WEST SUSSEX COUNTY COUNCIL CONSULTATION

TO:	Arun District Council FAO: Amber Willard
FROM:	WSSC - Highways Authority
DATE:	19 May 2022
LOCATION:	Longacre, Maypole Lane, Yapton, BN18 0DR
SUBJECT:	Y/60/22/PL Erection of 1 No detached dwelling and garage with shared access from Maypole Lane. This application is a Departure from the Development Plan and this site is in CIL Zone 3 and is CIL Liable as a new dwelling.
DATE OF SITE VISIT:	N/A
RECOMMENDATION:	Advice
S106 CONTRIBUTION TOTAL:	N/A

PROPOSED NEW DWELLING. PLANS AND ELEVATIONS

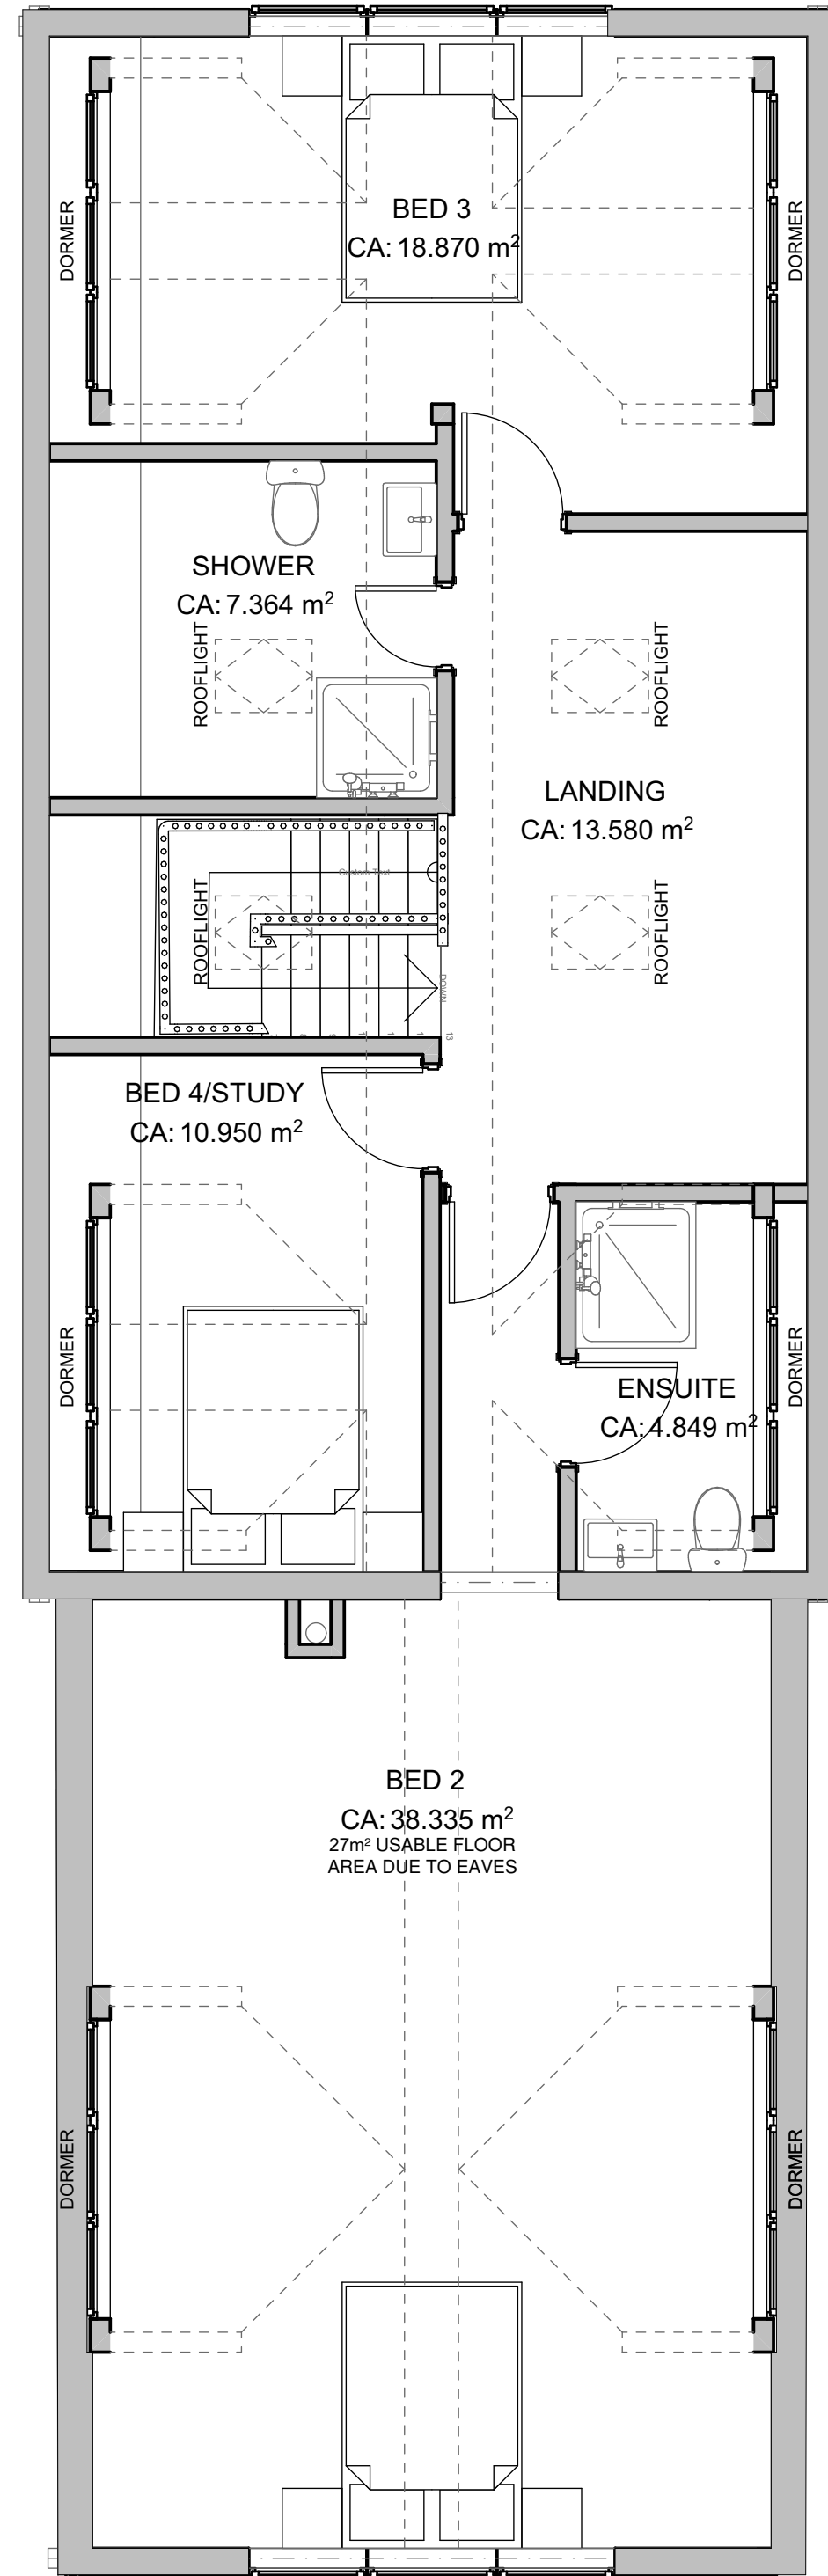
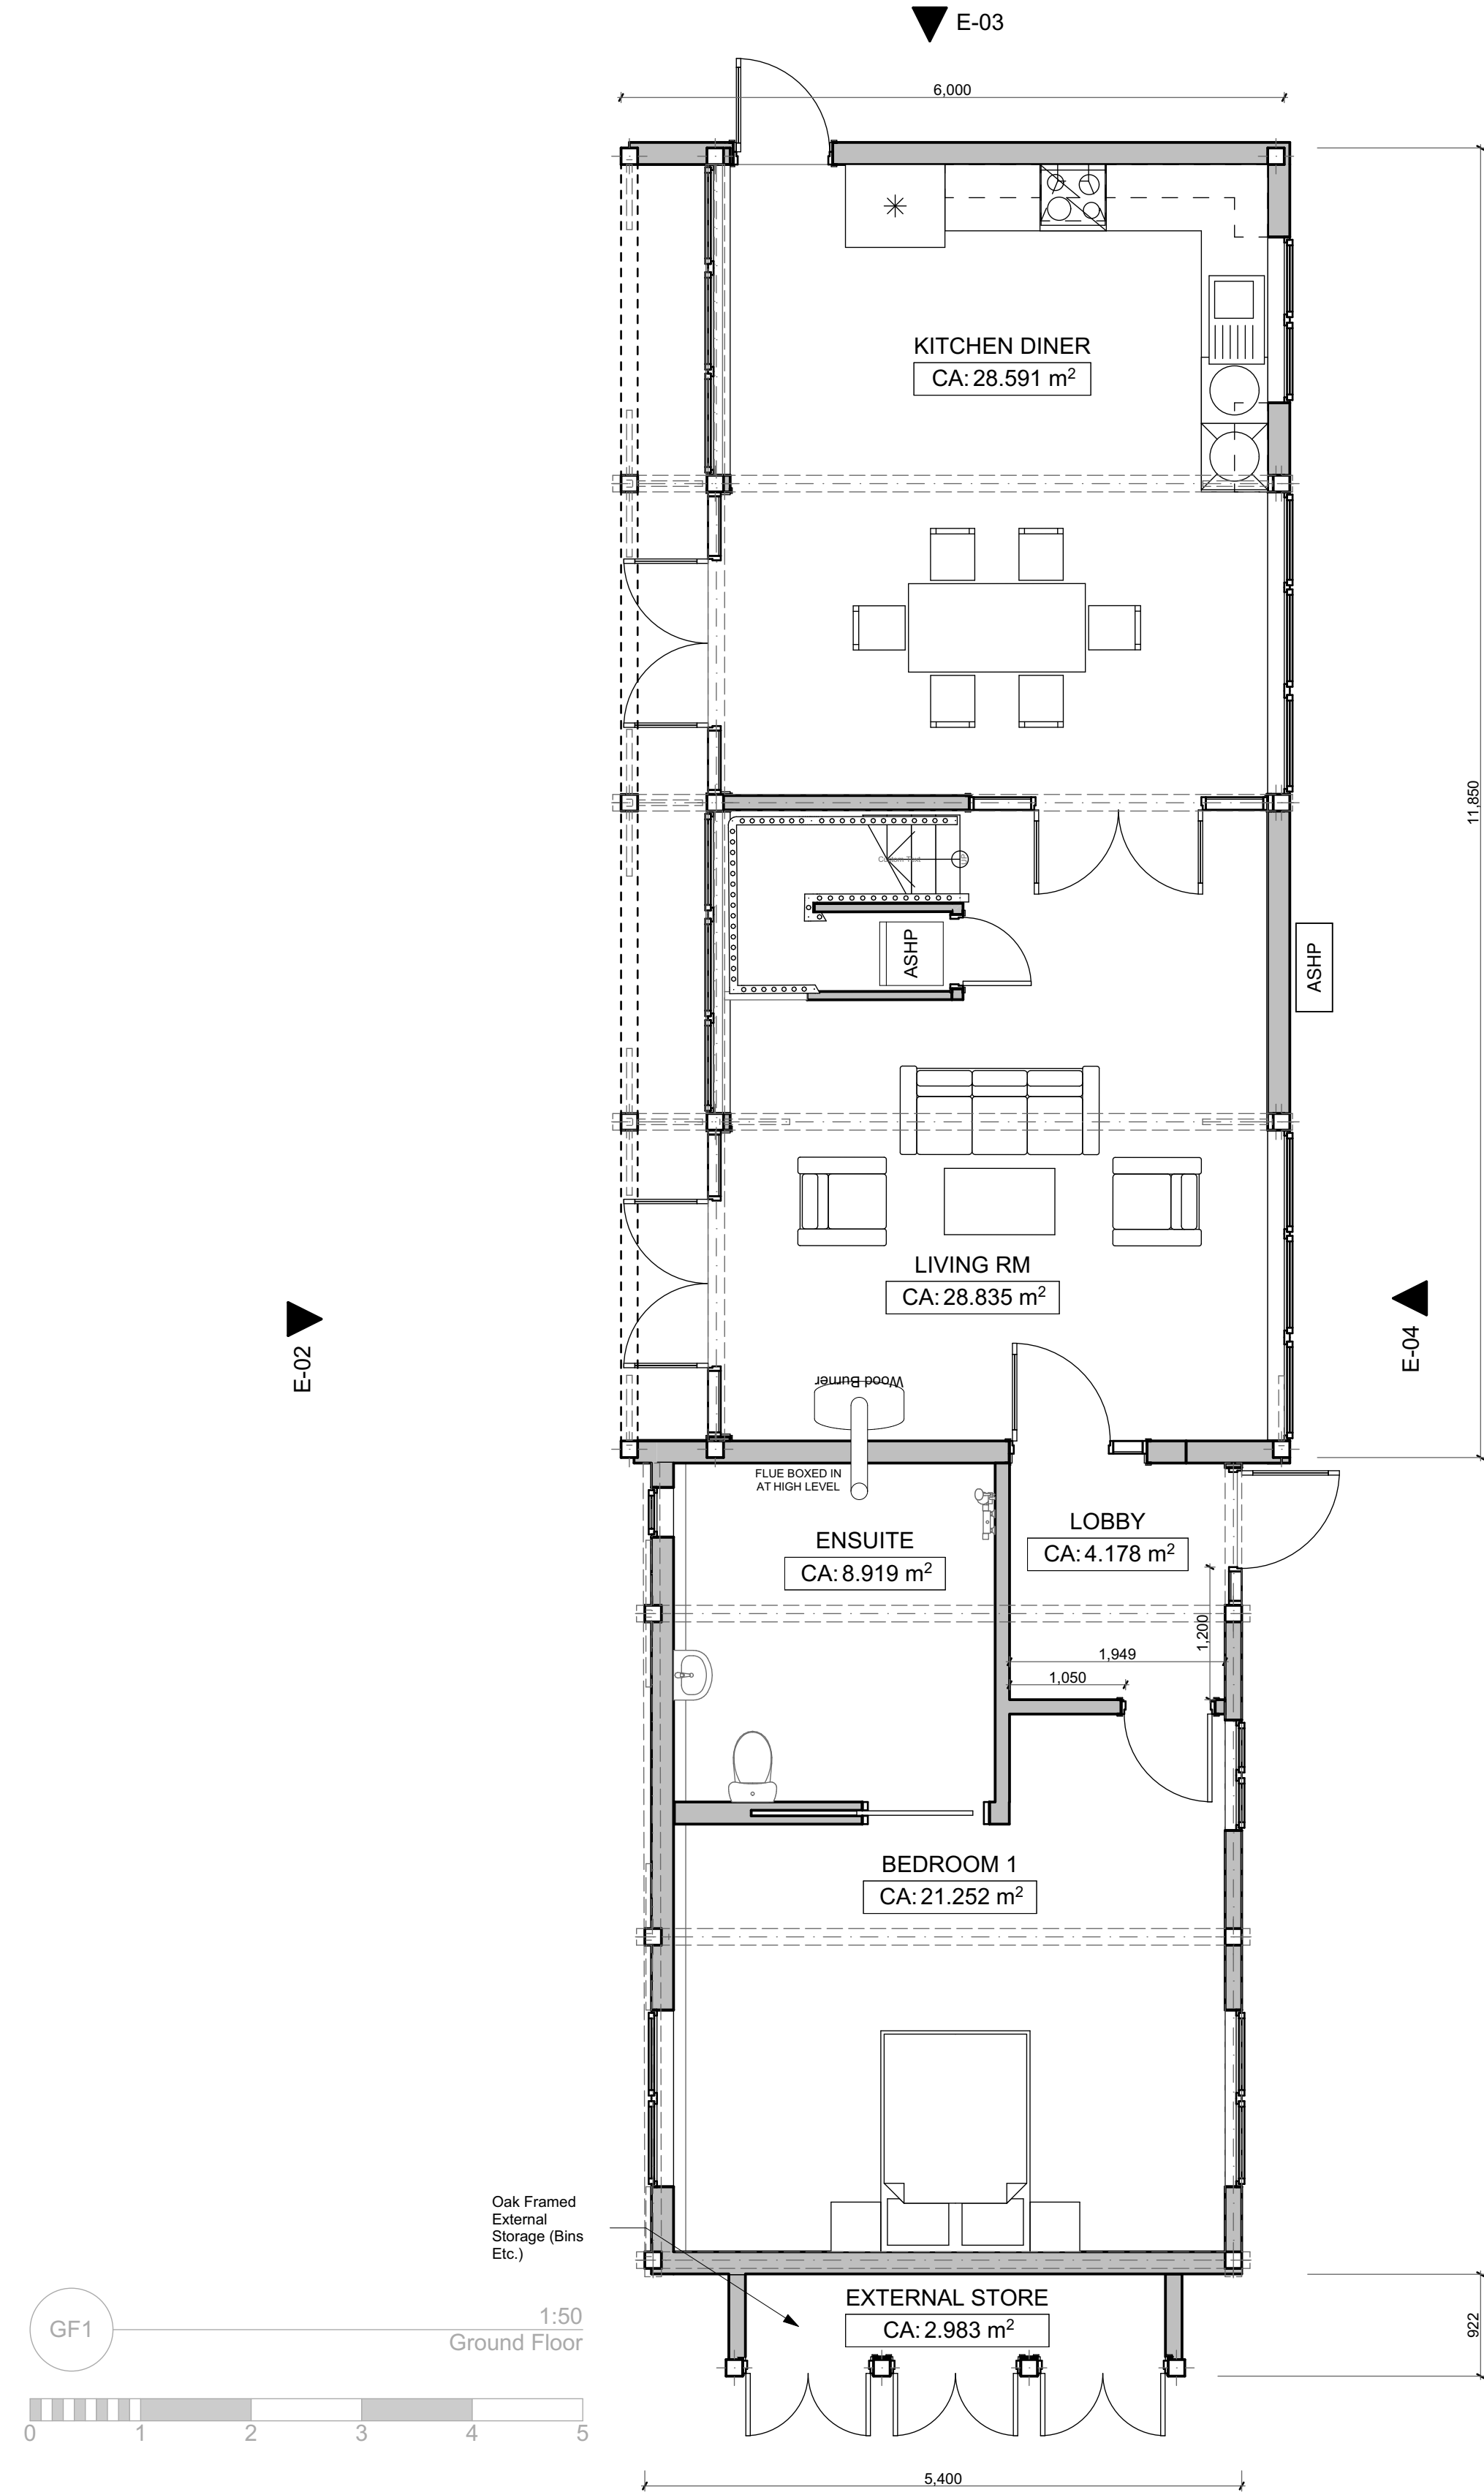
The applicant proposes a three-bay car port. Under Arun Parking Standards, the LHA would expect a dwelling of this size and location to provide three car parking spaces. Therefore, the LHA is satisfied with the proposed level of parking provision. From inspection of the plans, the proposed car port is suitably sized and on-site turning appears achievable.

Regarding cycles, the car port includes storage which can be utilised for cycle parking in accordance with Arun Parking Standards. The inclusion of secure cycle parking provision will help promote the use of sustainable transport methods.

No part of the development shall be first occupied until the car parking has been constructed in accordance with the approved site plan. These spaces shall thereafter be retained at all times for their designated purpose.

No part of the development shall be first occupied until covered and secure cycle parking spaces have been provided in accordance with plans and details to be submitted to and approved by the Local Planning Authority.
